Recommendation Report for Planning Permission for Works or Extension to a Dwelling

REF NO: P/122/20/HH

LOCATION: 28 Cardinals Drive
Pagham
PO21 4QF

PROPOSAL: Single storey rear extension to form kitchen/diner/lounge and utility area with bike store.

Proposed Ground Floor Plan & Roof Plan
Proposed Elevations
August 2020

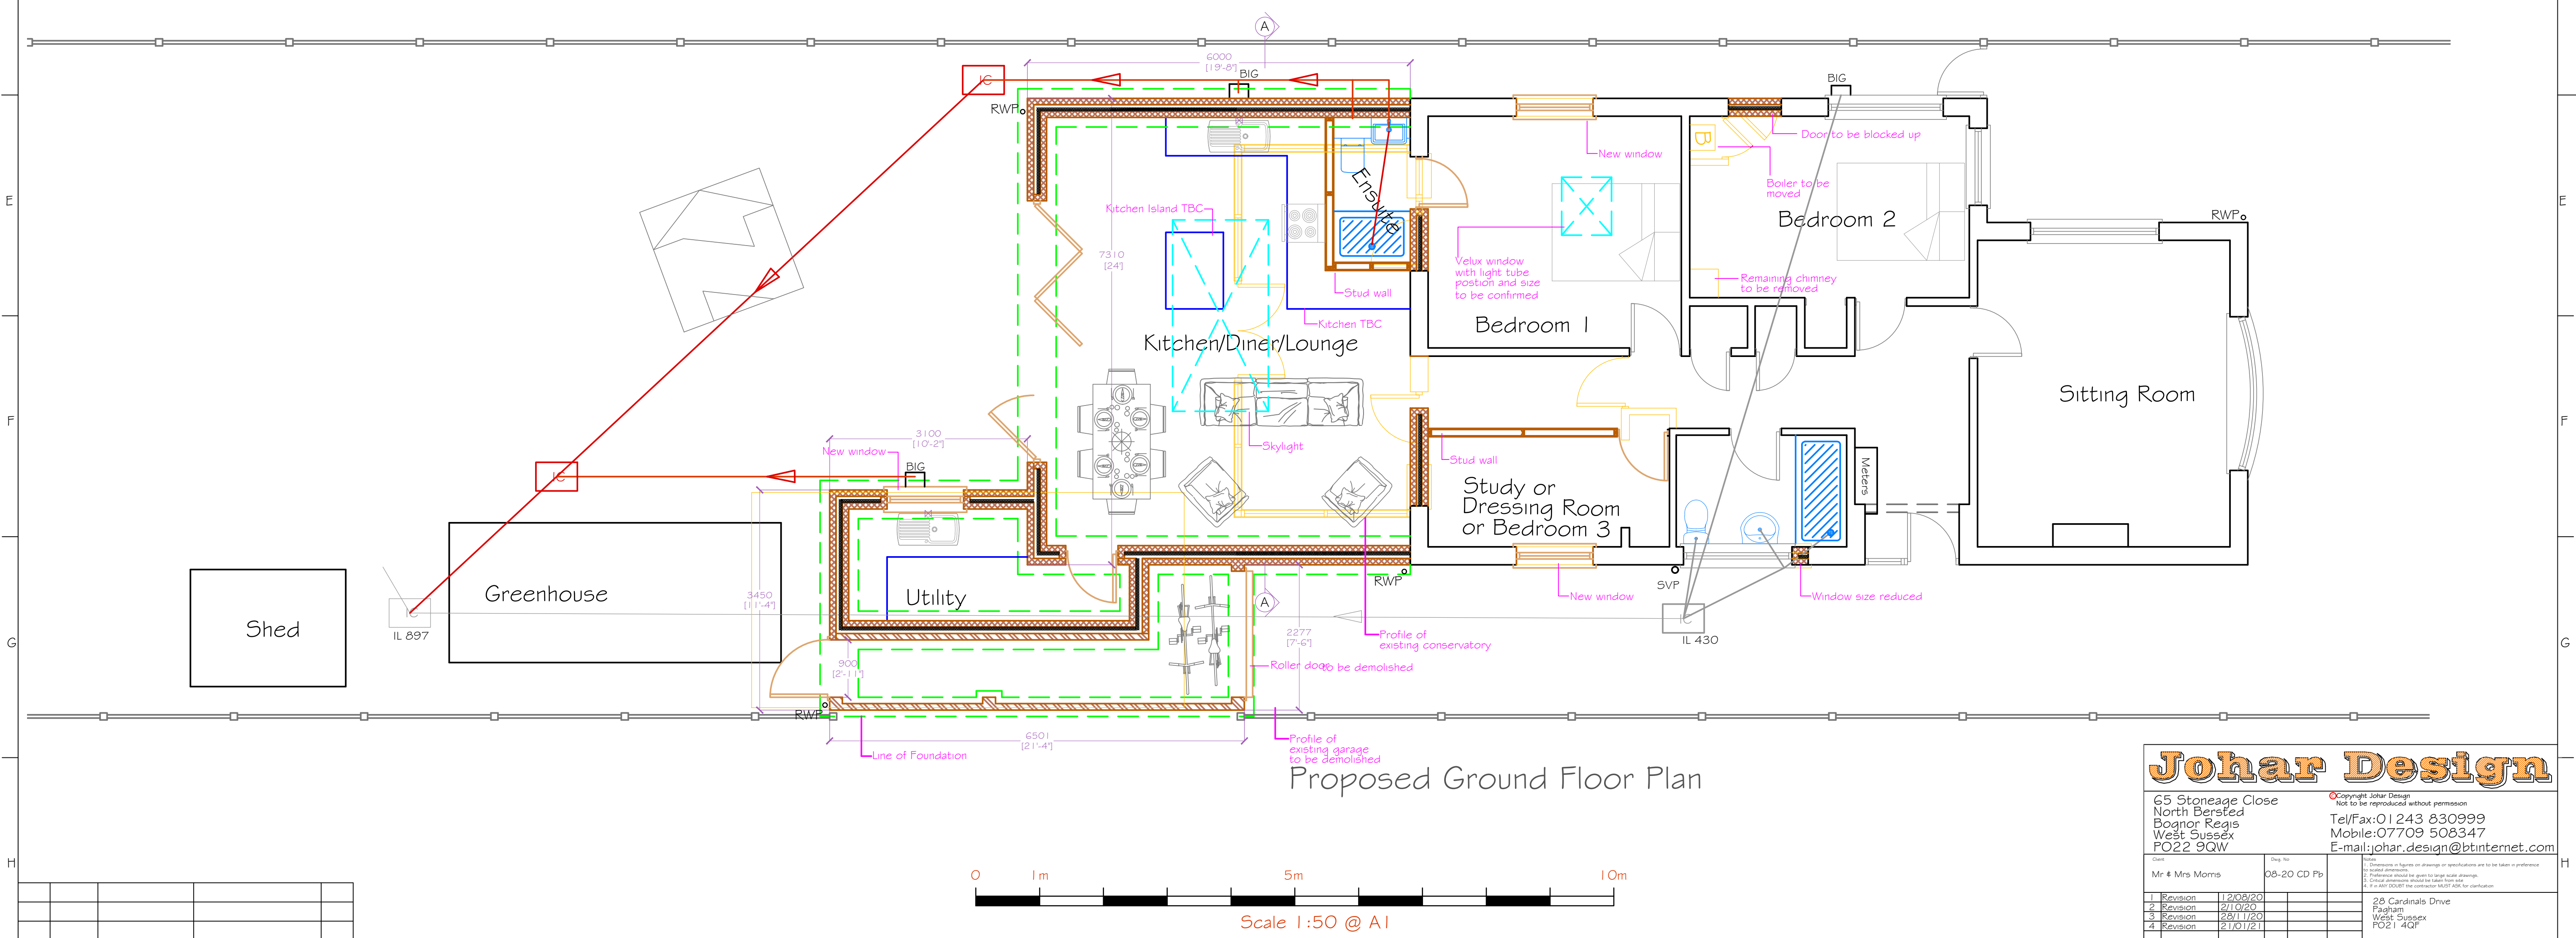
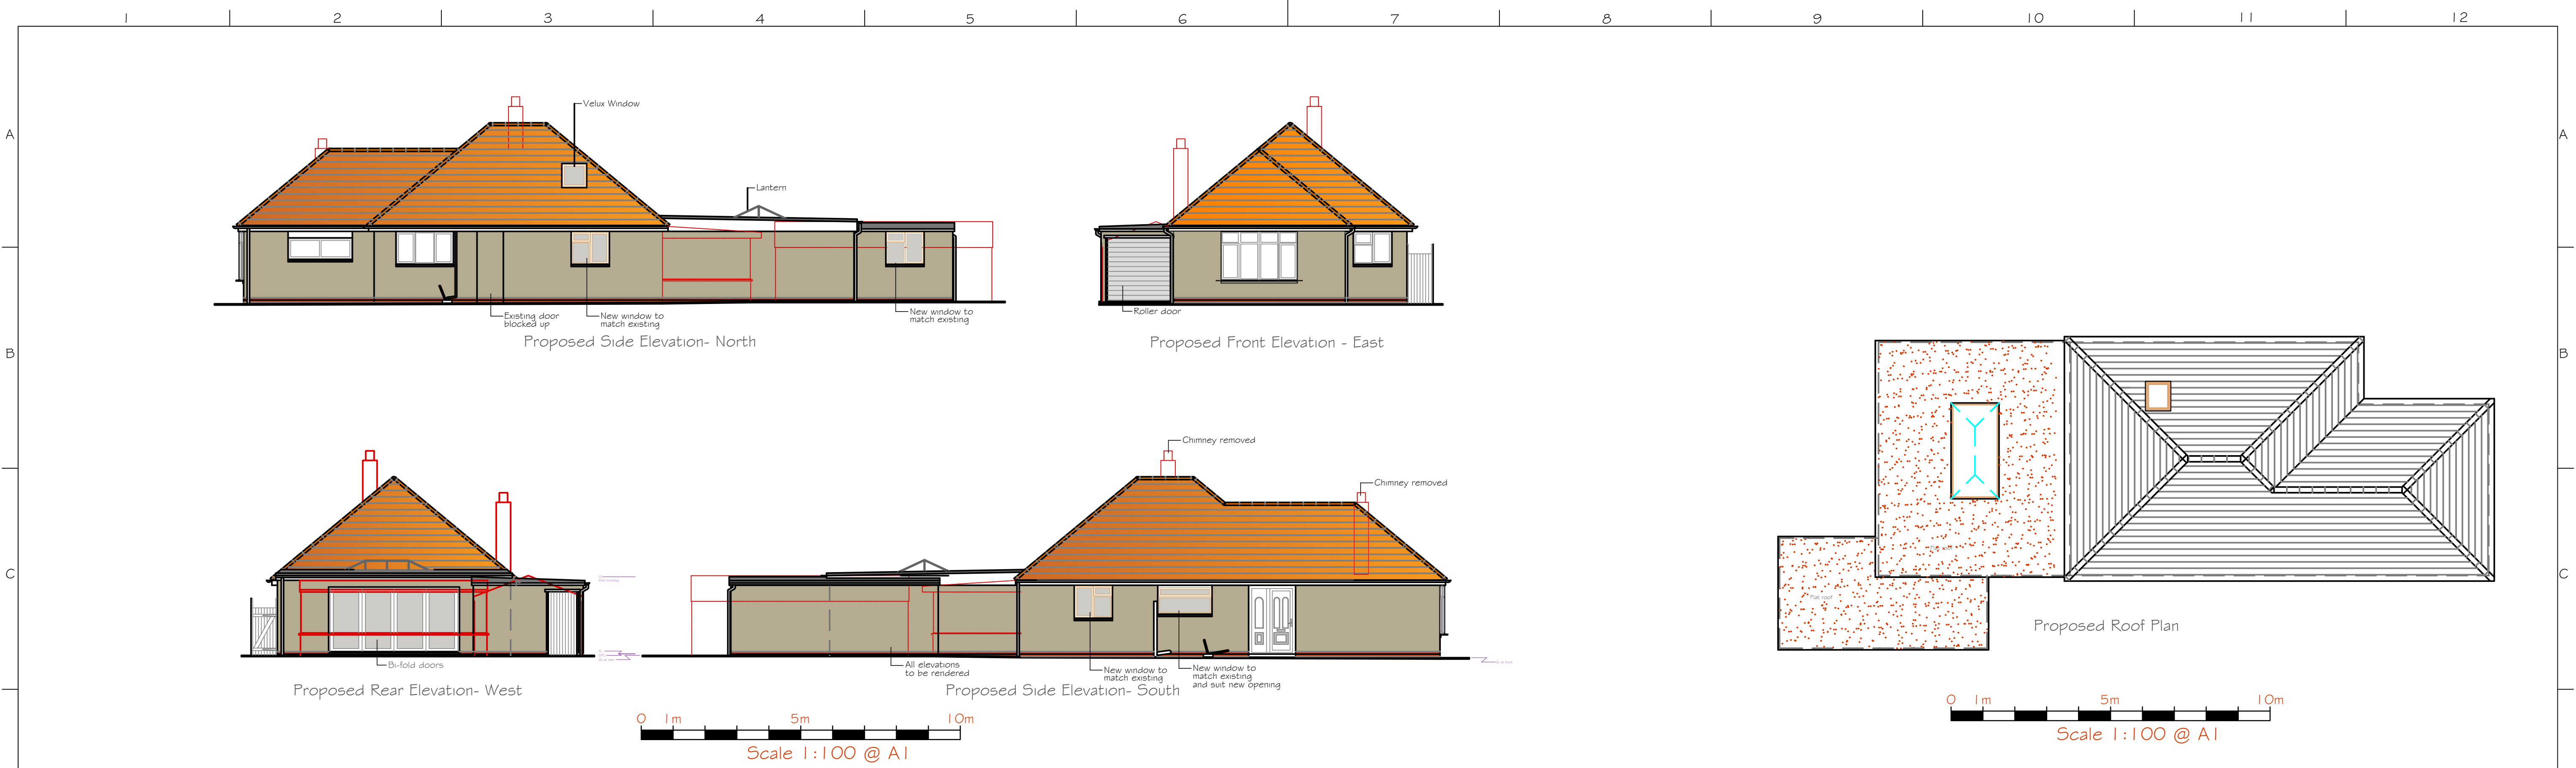
There is an existing conservatory which will be removed and replaced with an extension of 6m depth. This will have a flat roof with a height of around 2.7m.

The extension retains around 0.85m to the northern boundary and 2.3m to the south.

There is an existing garage to the southern boundary and this will be converted to habitable space to form a utility room and cycle storage area, linking with the extension. The conversion will also alter the roof from a shallow pitch to a flat roof, which is considered to reduce its impact upon the boundary.

The extension is considered to intersect a 45 degree angle when drawn from the centre of the windows to the rear of the property at the north and is likely to give rise to some overshadowing, being sited to the north. However this is not considered significant in which a refusal justified. The property would likely experience the same impact should a 4m extension be constructed which is permitted development and would not require permission.

Whilst the addition does extend beyond the rear of both properties, due to its modest height, it is not deemed adversely overbearing.

There will be no windows to the side of the extensions, with new windows to the rear overlooking the garden of the host dwelling.

Comments noted. Amended plans were submitted which reduced the height and depth of the scheme.
